Our ref: 23/10433/PREP  
Enquiries to: Mr Daniel Allen  
E-mail: [daniel.allen@eastriding.gov.uk](mailto:daniel.allen@eastriding.gov.uk)  
Telephone: (01482) 393845  
Date: 4<sup>th</sup> August 2023

<b>Proposal:</b>	Proposed demolition of farm buildings and erection of 2 lodges to be used as holiday let
<b>Location:</b>	Top Holme Farm, South Newbald Road, South Newbald, East Riding Of Yorkshire, YO43 4SU

Project	PROPOSED HOLIDAY LET TOP HOLME FARM, SOUTH NEWBALD,	
Drawing No.	2302-06 A	Scale 1 : 100
		Date 10/04/23

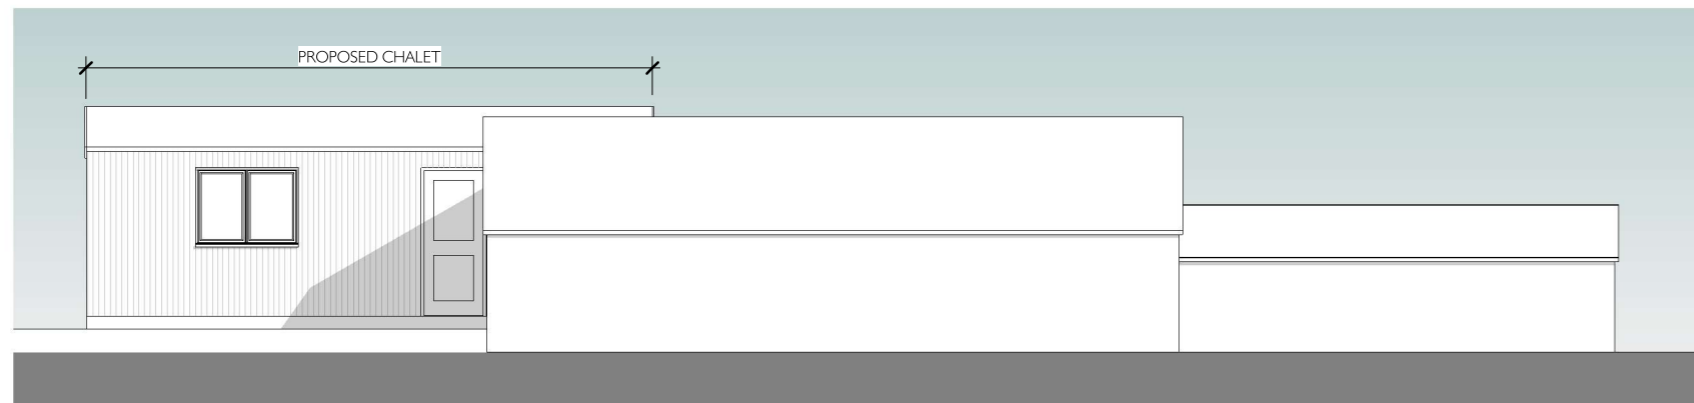
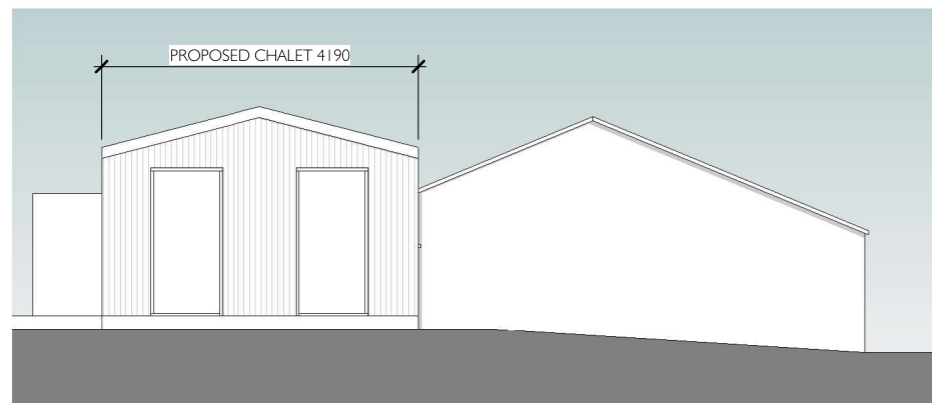
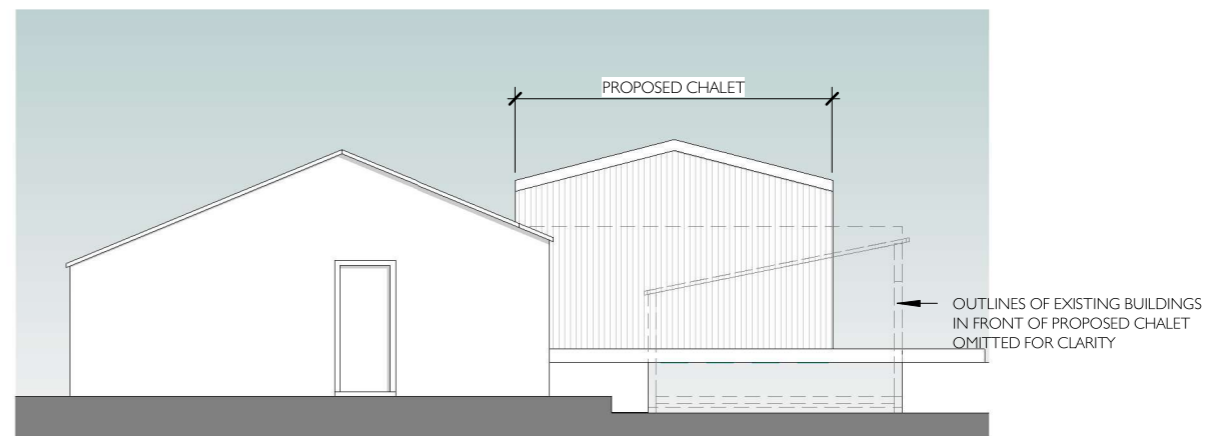
The two holiday accommodation units would be sited in a similar location to the existing concrete block and sheet roof outbuildings (following their demolition), to the east of the main dwelling at Top Holme Farm with each provided with an area of external amenity space to the rear. The details provided show two different lodge forms, one measuring approx. 7.3m x 5m with a shallow pitched roof 2.8m in height, the other measuring approx. 6m x 5.1m with a steeper pitched roof at 3.71m.

Whilst the existing buildings are not considered to contribute significantly toward the character and appearance of the conservation area, they are nevertheless, of a typical rural character (minimal and of few openings). In contrast, the proposed holiday accommodation units would alter the character of the site, and likely to a domesticated appearance which, on the basis of the present site layout, appears to 'spill' into the meadow area to the south. Such an increased domestication and visibility of such paraphernalia could be quite a significant change to the site, and may not preserve or enhance the character and appearance of the village conservation area or, likewise, protect and enhance the landscape character of the Yorkshire Wolds Important Landscape Area.

BLOCK PLAN
1 : 500

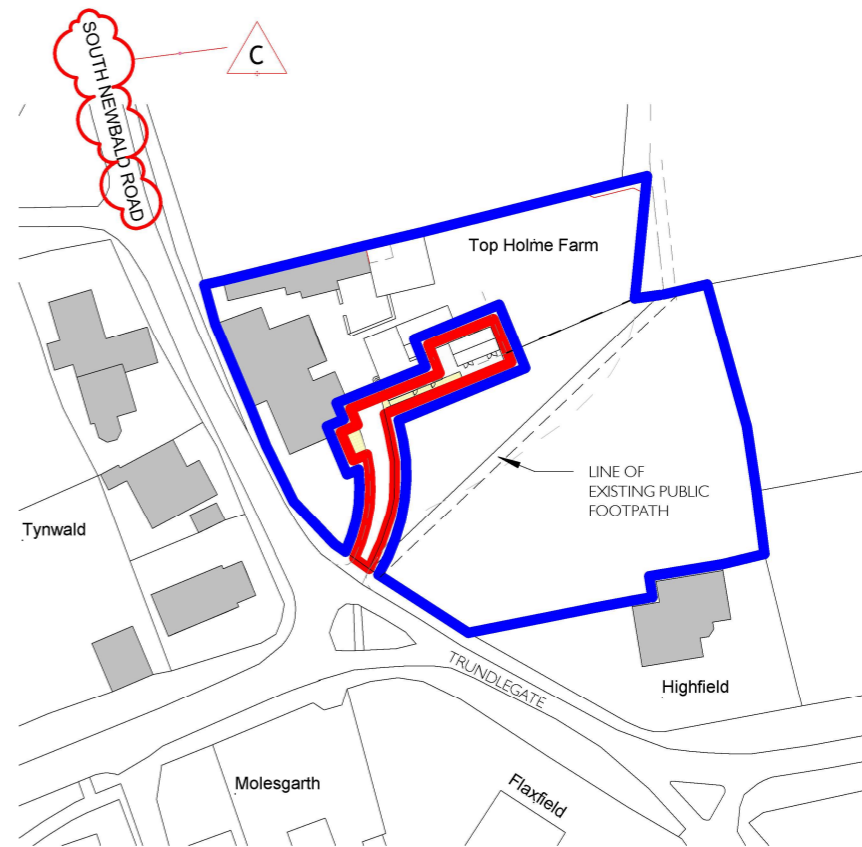
From the submitted details it would appear that the existing site access is proposed to be utilised for the lodge development, leading to three off-street parking spaces. However, the manoeuvring space around these parking spaces appears constrained by the width of the driveway and adjacent fencing.

Whilst limited details have been provided with this enquiry, it would appear that the proposals concern the re-siting of the existing Public Right of Way (PRoW) which crosses land to the south of the proposed lodge site. Having regard to the Council's 'Public Rights of Way and Planning Guidance Document', any such proposals would require a Public Path Order (PPO).
